TECHNICAL NOTE

Project	Swallowfield Way, Hayes
Document	Transport Note
Reference No	24004/N01
Prepared By	Kamran Haider
Reviewed By	Amelia Goswell
Date	29/05/24

Reference 72037/APP/2024/28

Proposal Erection of a two-storey extension to existing warehouse unit (use class B8) and associated parking.

| REV. | DATE | DESCRIPTION |
|---------------------------------|------|--|
| EXISTING AND PROPOSED SITE PLAN | | |

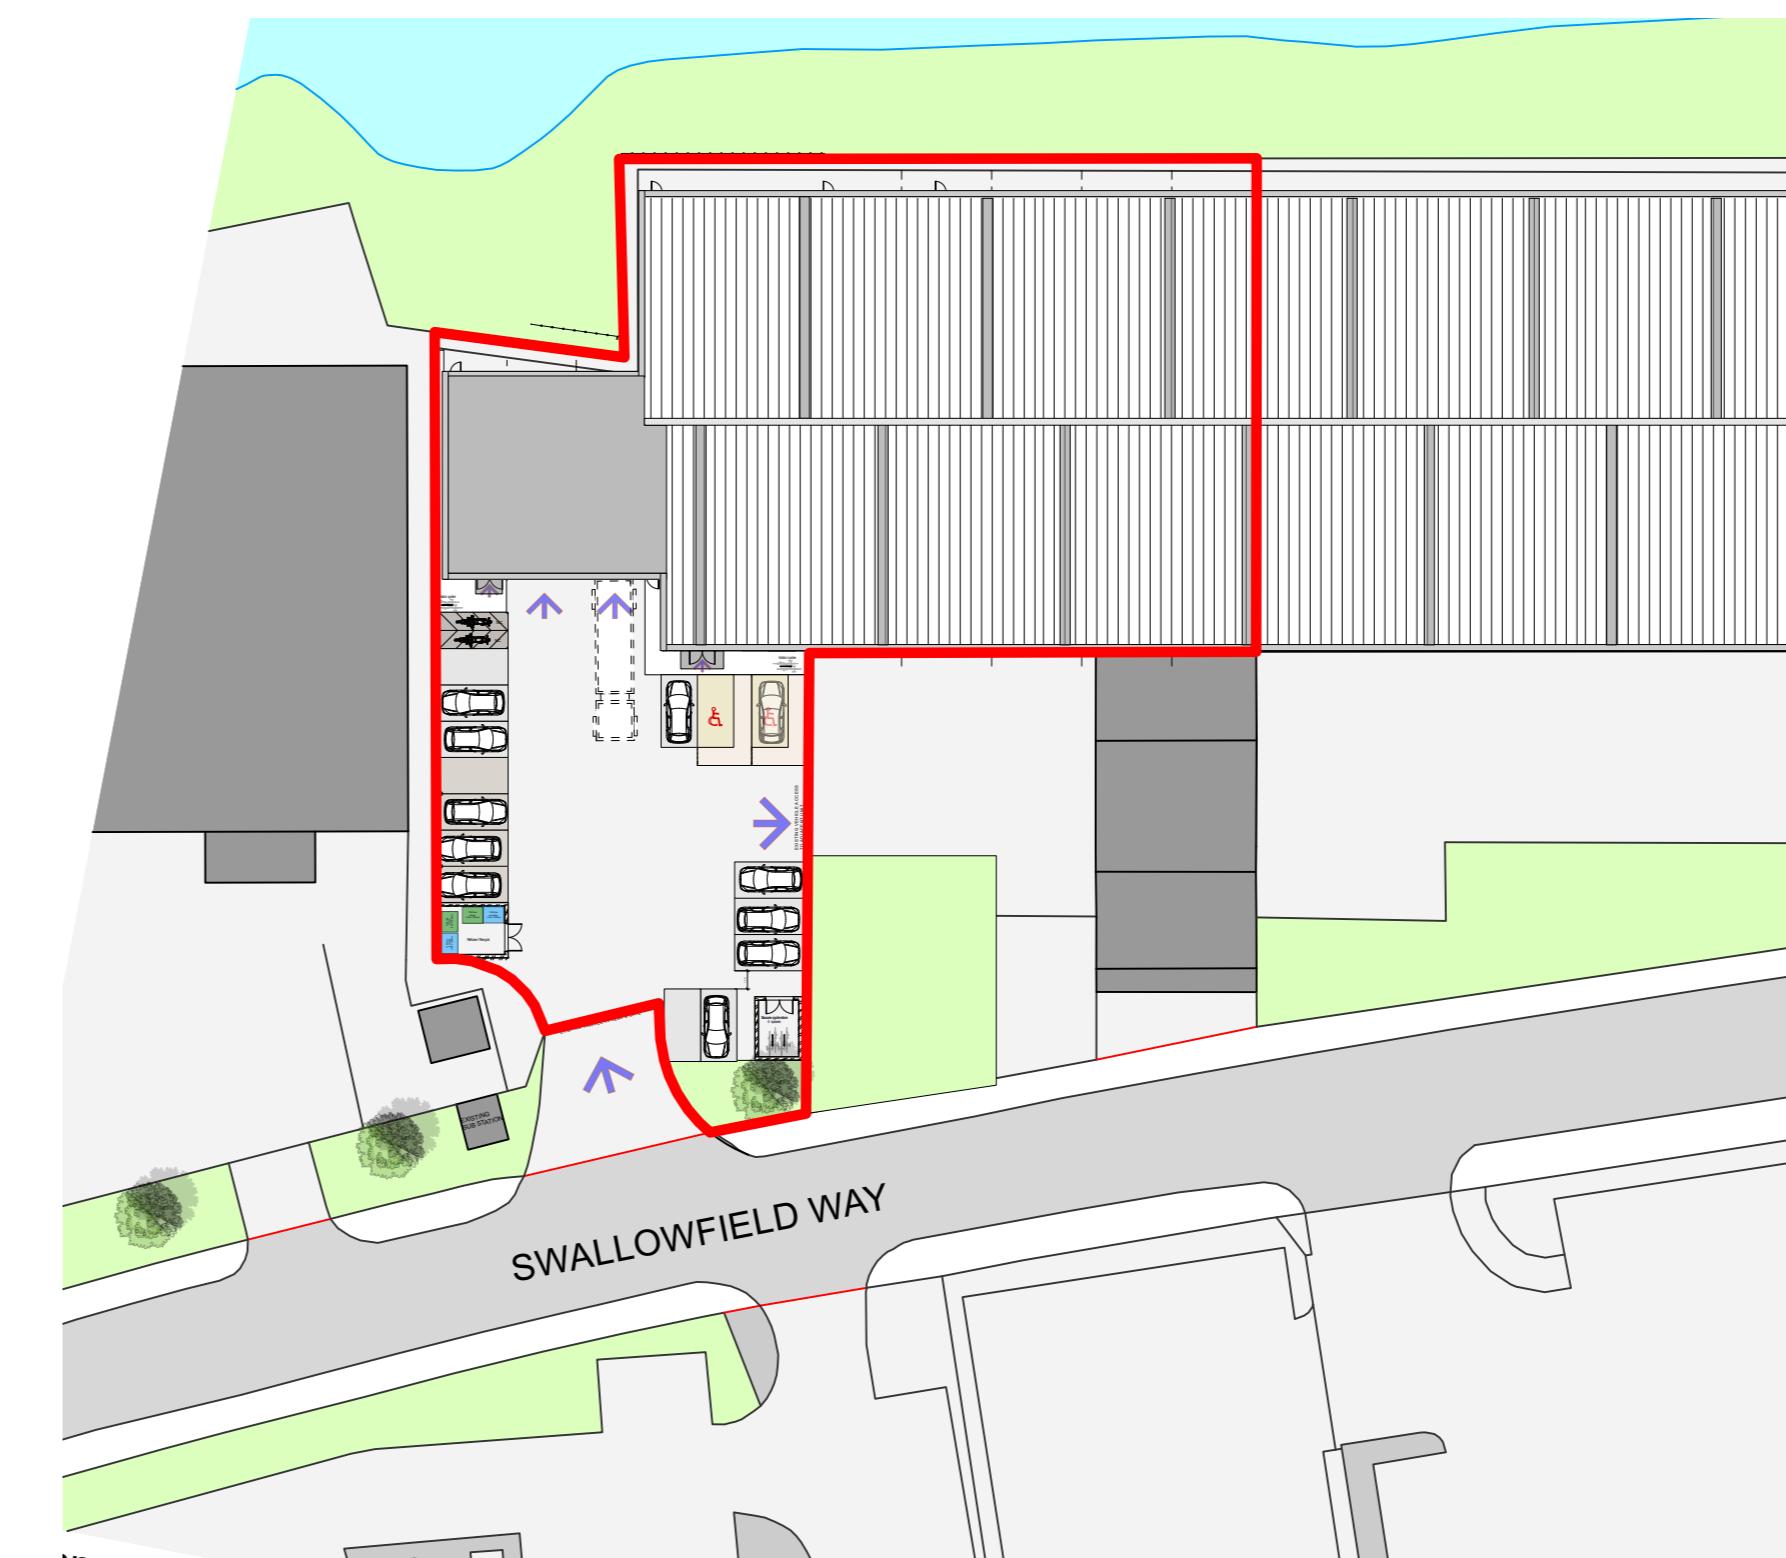
Access to the application site would be gained from the existing vehicular access from Swallowfield Way which is shared with the adjacent unit to the east on Swallowfield Way and would remain acceptable, however, swept path analysis would be required for a 16.5m articulated HGV design vehicle entering the application site, turning and docking.

The proposed 2240m² site would therefore require that between 20-37no. spaces should be provided and as the application site has a low PTAL of 1b the number of spaces provided should be at the higher end. The Design and Access Statement 7.1 Vehicular & Cycle Parking shows 16no. car parking spaces including 2no. disabled parking spaces which would fail to concur with the Local Plan and would not be acceptable. The Planning Statement paragraph 5.3.6 states that the development of a further '*c. 300 sqm of additional floorspace*' would result in negligible impacts on trips, however, this is incorrect as the development would provide an additional 480m² which would be an additional 28% floor area which would not be considered 'negligible' and is therefore not acceptable.

26. A total provision of 16 car parking spaces is therefore proposed on site, including two disabled bays adjacent to the building. 20% of bays would have active Electric Vehicle Charging (EVC) points, with the remainder hosting passive provision.

27. Two motorcycle bays are additionally provided, as per LBH parking standards.
28. Swept path analysis of the bays is shown in **Drawing 24004/TR001** at **Appendix D**. This demonstrates all bays can be accessed/egressed without issue.

29. A total of 8 cycle spaces are proposed on site, in excess of London Plan standards, to encourage travel by bicycle to the site.
30. A new cycle store would be provided adjacent to the site's frontage onto Swallowfield Way, containing 4 long-stay spaces. Additional cycle parking would be provided by both of the building's entrances, with two Sheffield stands providing 4 short-stay spaces. Access to the proposed cycle parking spaces has been amended to address LBH's comments. Further cycle parking could be provided on site if demand required this.

PROPOSED SITE PLAN - Transport & Servicing

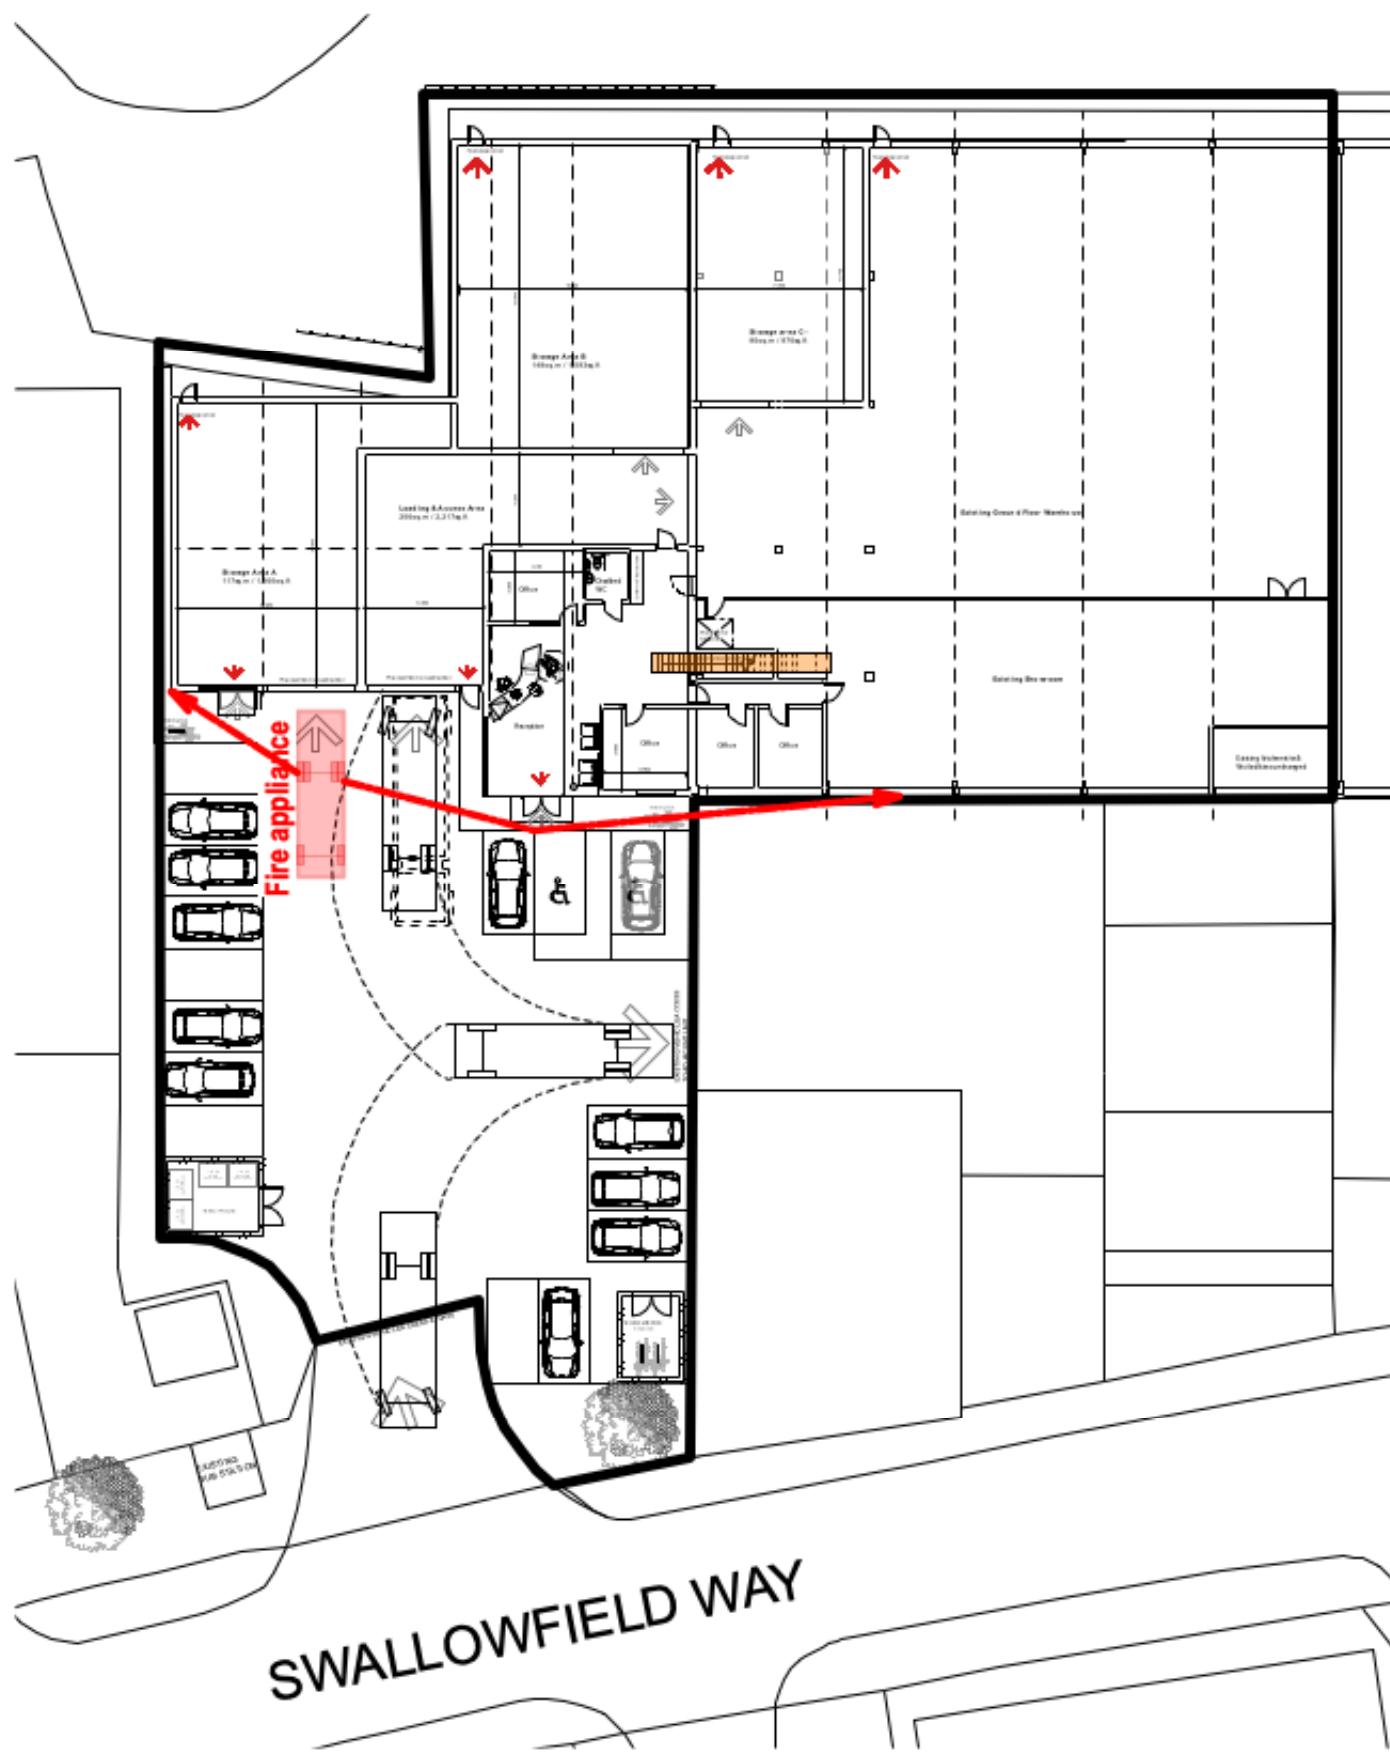
The Design and Access Statement dated February 2024 7.1 Vehicular & Cycle Parking shows a blue dashed line denoted as '*Tracking for service vehicle*' which is not acceptable. A swept path analysis using AutoTrack would be required which should include 1no. design vehicle reversing into the easternmost dock whilst a design vehicle is parked in the westernmost dock and 1no. design vehicle reversing into the westernmost dock whilst a design vehicle is parked in the easternmost dock. All vehicles must be able to enter and leave the application site in a forward gear.

The unnumbered drawing provided in the Design and Access Statement 7.1 Vehicular & Cycle Parking shows short shows 2no. short stay cycle stores. 1no. cycle store is located clos to the entrance to the development which would be acceptable. 1no. short stay cycle store and the long stay cycle store are shown remote to the entrance to the development and should be relocated closer to the entrance in a position where natural surveillance should be provided.

Concerns are also raised regarding the dimensions of the cycle stores. Drawings should be providing the internal layout of the stores in the relocated positions and should also demonstrate access.
